Per Jeff Rice's EDARP comment on 9/14 when he requested the GEC Plan be separated from the Site Development Plan file:

INITIAL EROSION CONTROL PLAN		COLORADO
SUPER STAR CAR WASH - FALCON MARKETPLACE LOT 10		EL PASO COUNTY
SITE DEVELOPMENT PLAN

SUPER STAR CAR WASH - FALCON MARKETPLACE LOT 10

NOT FOR CONSTRUCTION		
DESIGN SWK	DRAWN SWK	CHKD TOP
SCALE: H: 1" = 20' V: 1" = XXX'		
JOB No. 020441-01-001		
DATE: 02/09/2021		
SHEET C2.1

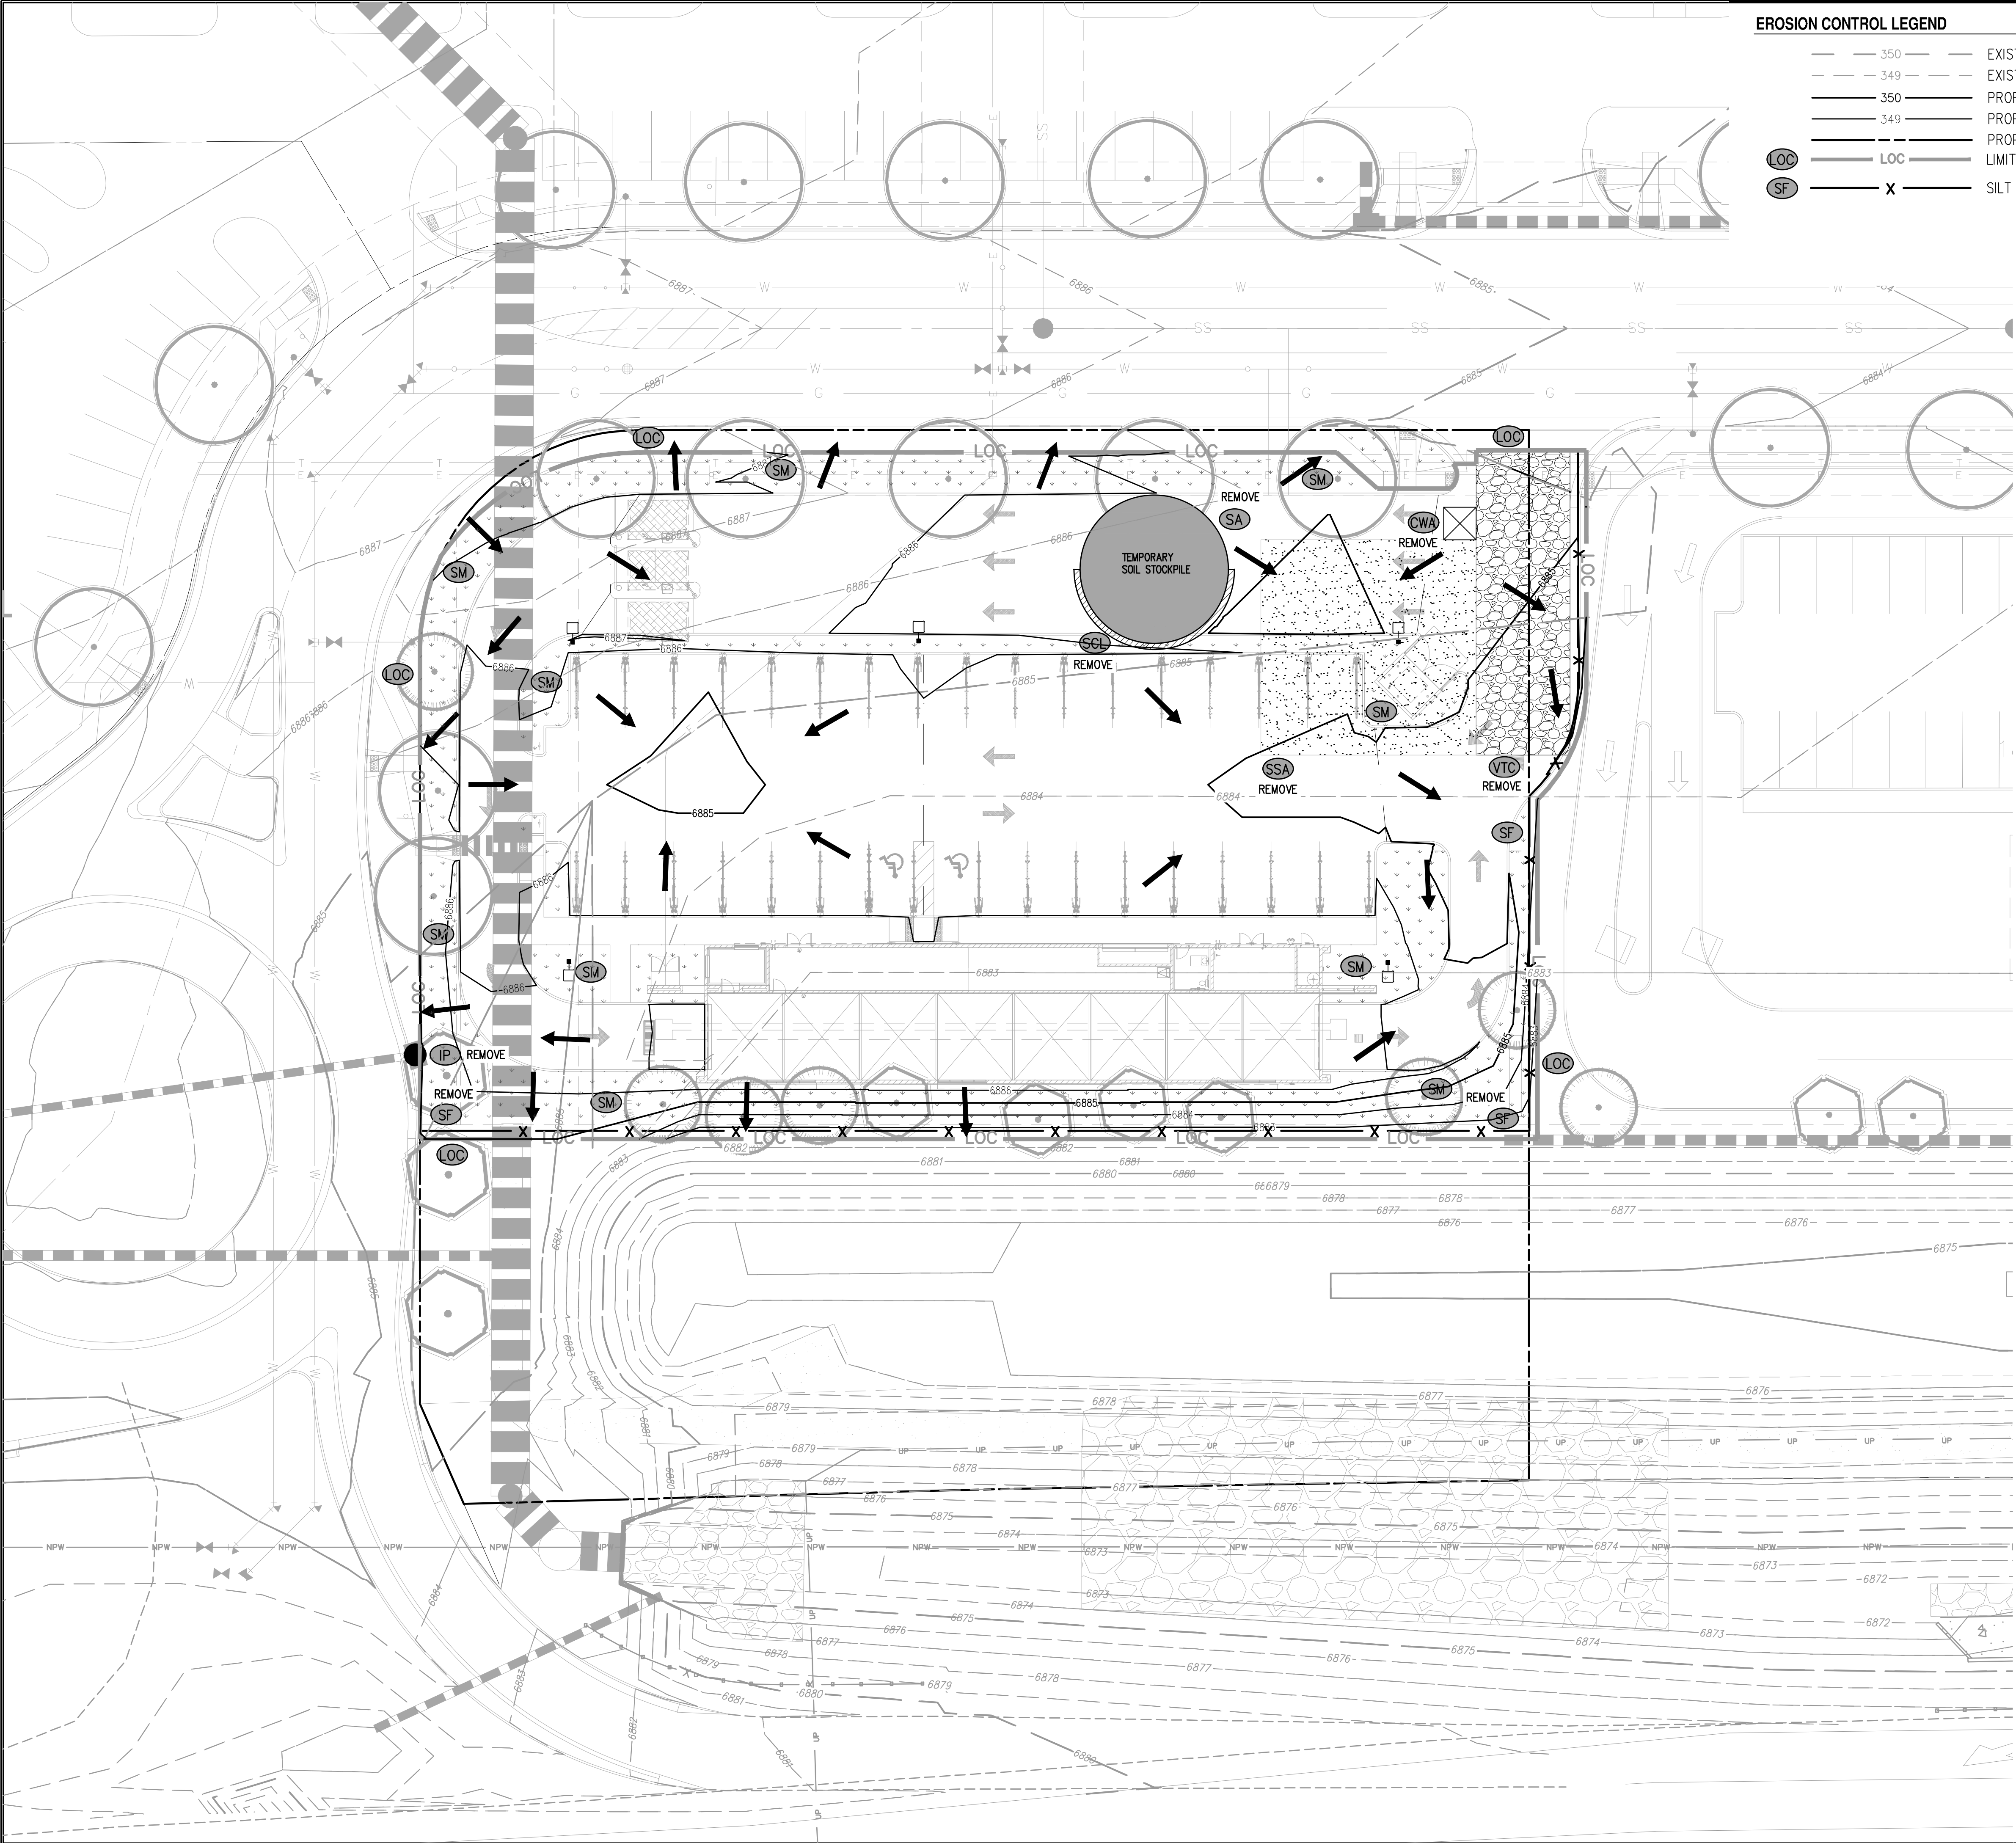
Items H and M. If "limits of disturbance" and "construction boundary" are the same, change to "limits of construction/disturbance" or otherwise show as separate line types for each on the legend and figure.

GEC Checklist Items H and M:
If "limits of disturbance" and
"construction boundary" are the
same, change to "limits of
construction/disturbance" or
otherwise show as separate
line types for each on the
legend and figure
(typical comment all plan shts)
